**KIRKLEES METROPOLITAN COUNCIL
INVESTMENT & REGENERATION SERVICE**

DELEGATED DECISION TO DETERMINE PLANNING APPLICATIONS

Reference No: 2020/62/92777/E

Description: Erection of detached dwelling

Title: Proposed Site Plan

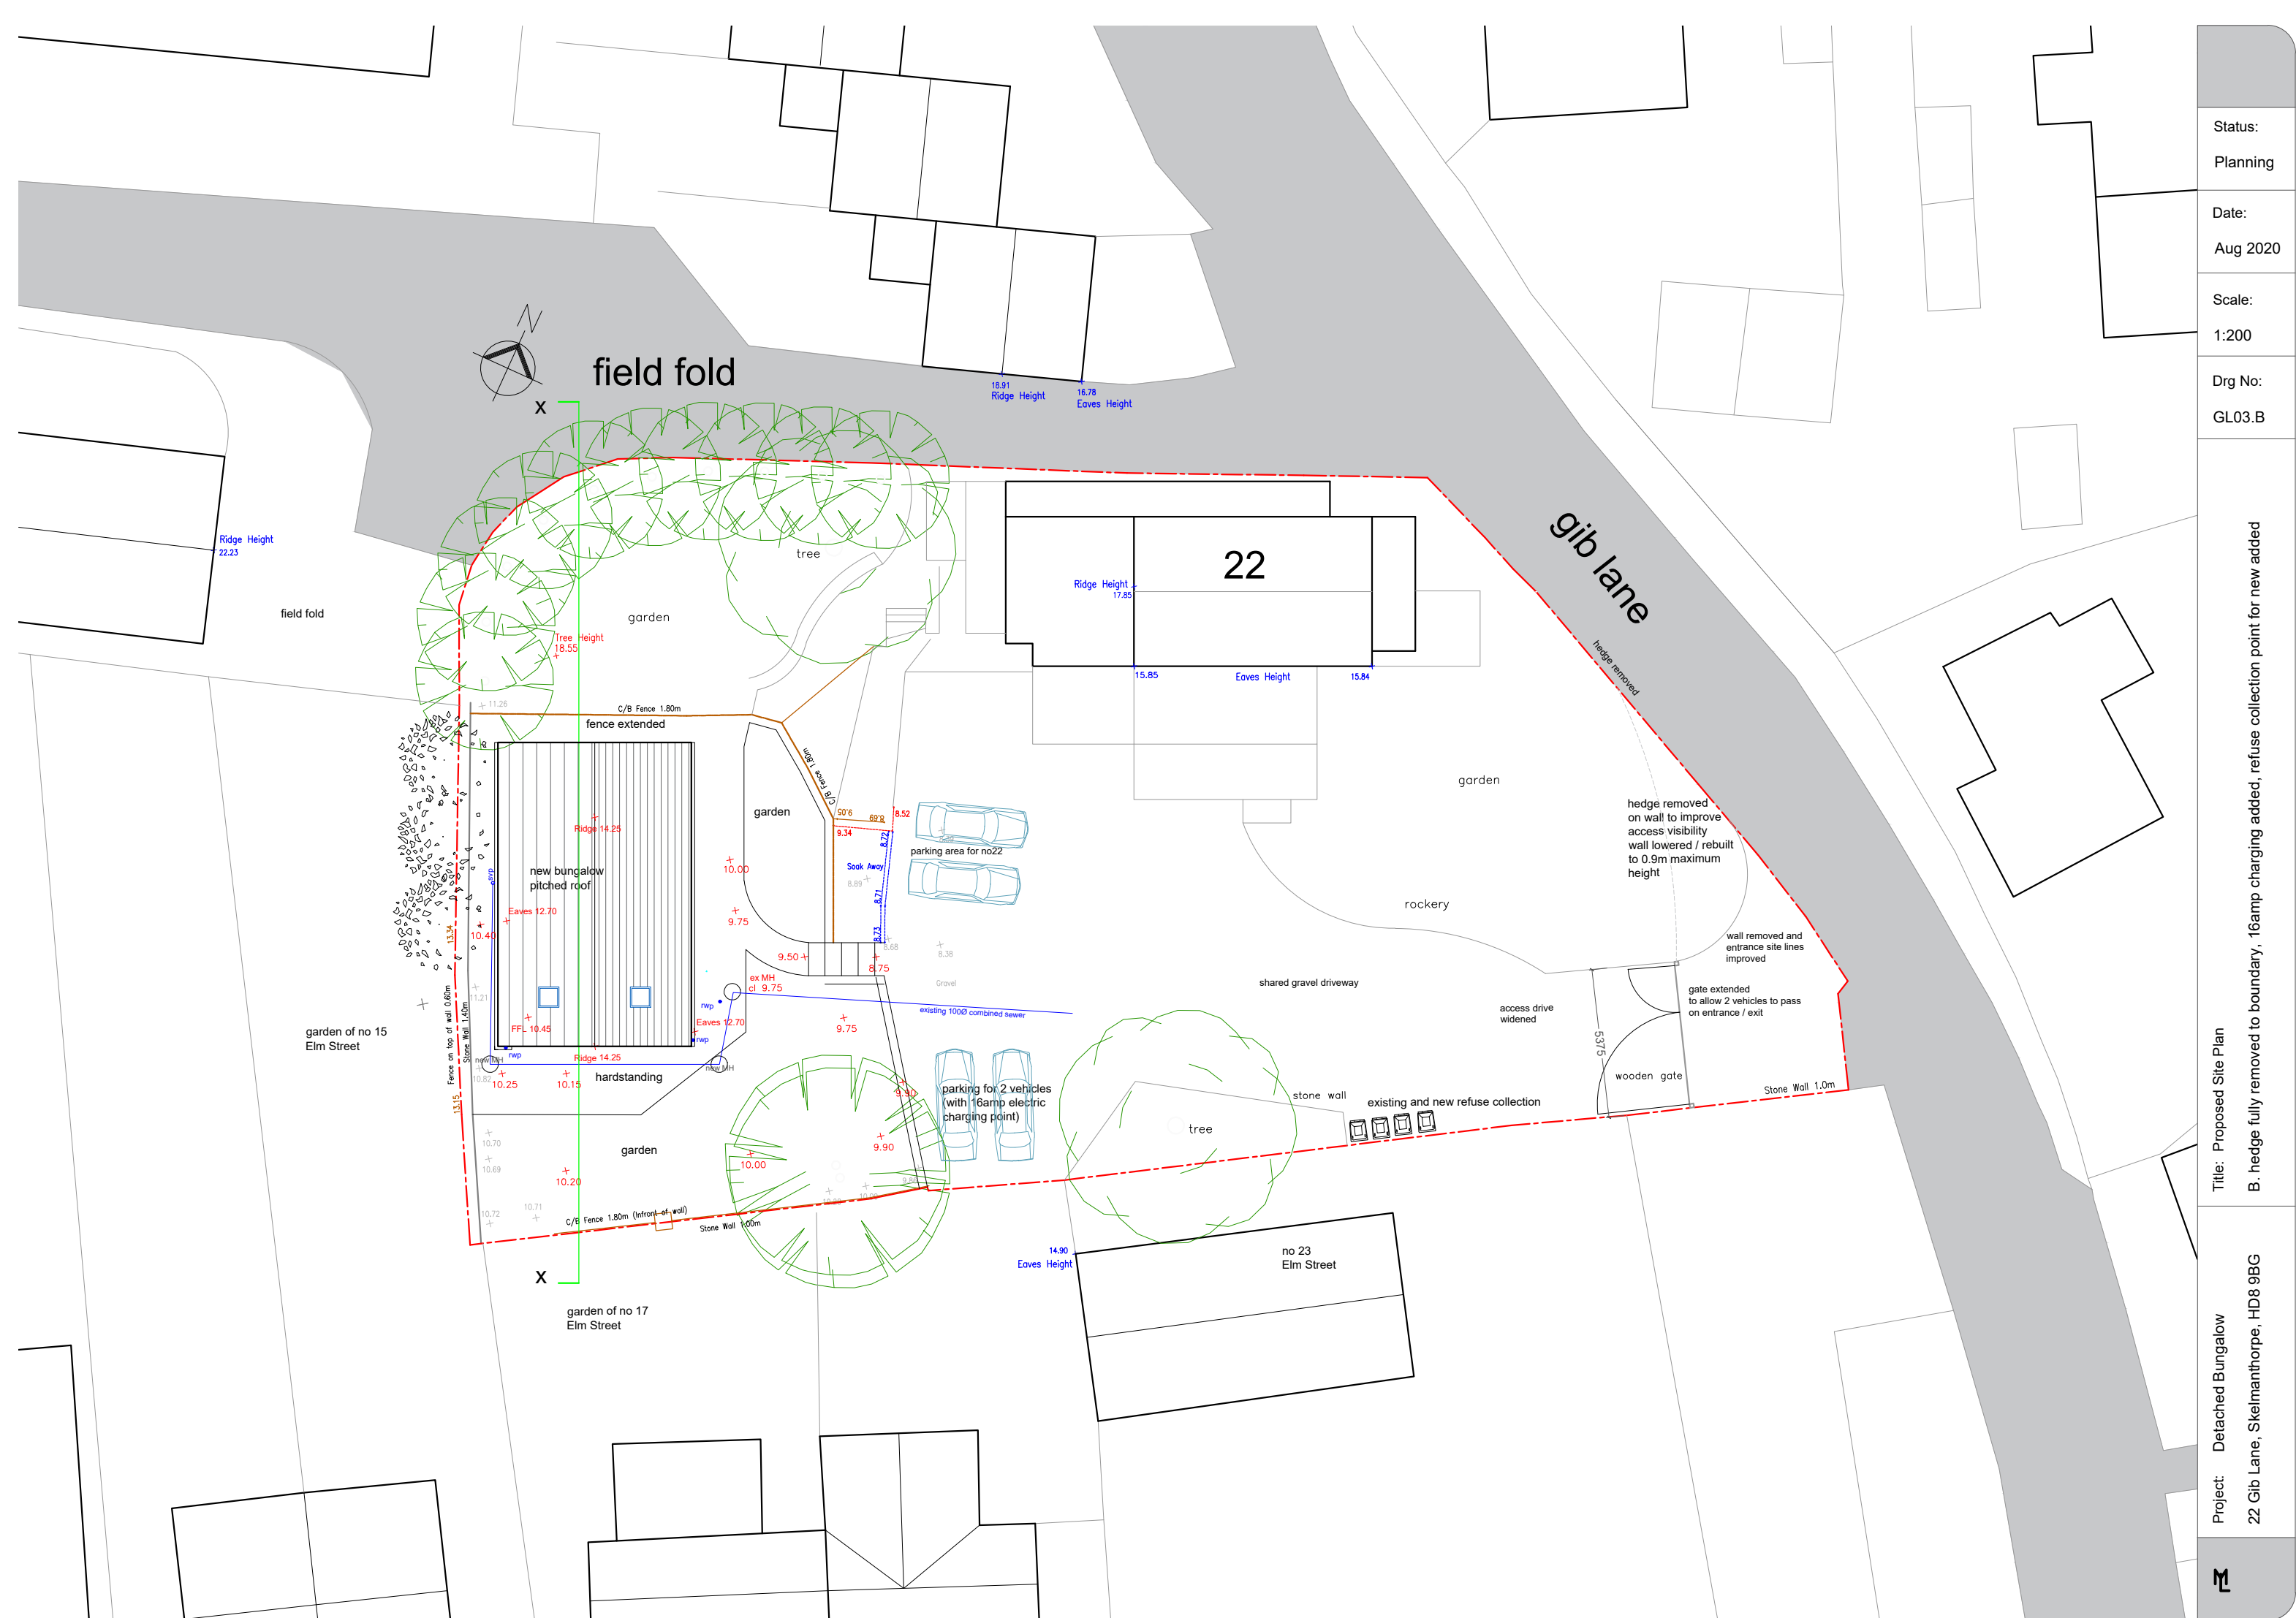
KC Highways DM Team – We consider the proposal is acceptable in principle, however further details regarding the boundary treatments across the frontage of the site should be provided to ensure that the visibility from the site entrance is preserved.

Access to the new house would be through the existing driveway serving 22 Gib Lane. Referring to the proposed site plan, this driveway would be widened to 5.4m to allow two vehicles entering and exiting the site simultaneously. The existing stone boundary wall abutting Gib Lane would be lowered to 0.9m with the hedge immediately behind removed, to improve visibility from the site access. This would adequately address the initial concerns raised by the Highways DM Team.

Policy LP28 of the KLP establishes a hierarchy of drainage solutions with a Sustainable Urban Drainage System being the most preferable solution and Main Sewer the least preferable option. The application form states that all surface water is to be discharged to the main sewer. Conversely, the site plan indicates that a soakaway is to be installed to the front of the house but falls short of providing any evidence to demonstrate it is a workable drainage solution for the site. This is not consistent with the aims of the drainage policy in the KLP.

In the interest of highway safety, a condition should be imposed to require that the existing boundary treatments along the frontage of the site should be altered in accordance with the details in the proposed site plan before the new dwelling is brought into use. In addition, it should stipulate that nothing higher than 1.0m should be erected or planted across the site frontage. Subject to this, there would be no issues concerning visibility and highway safety.

7. The dwellings hereby approved shall not be brought into use the existing stone boundary wall along the frontage of the application site has been reduced to 0.9m and the hedge directly behind removed, in accordance with the approved site plan. . Notwithstanding the provisions of section 55(2)(a)(ii) of the Town and Country Planning Act 1990 and the Town and Country Planning (General Permitted Development) Order 2015 (or any order revoking or re-enacting that Act or Order with or without modification), nothing higher than 1.0m, measured from the ground level of Gib Lane, shall be erected or planted along the frontage of the site at any time without prior approval of the Local Planning Authority in writing.

8. Notwithstanding the information in the application form, a scheme detailing surface water and land drainage shall be submitted to and approved in writing by the Local Planning Authority before development on the superstructure of the new dwellings commences. Where soakaways are proposed, the submitted scheme shall demonstrate an adequately designed soakaway as an effective means of drainage of surface water on the site. Where a septic
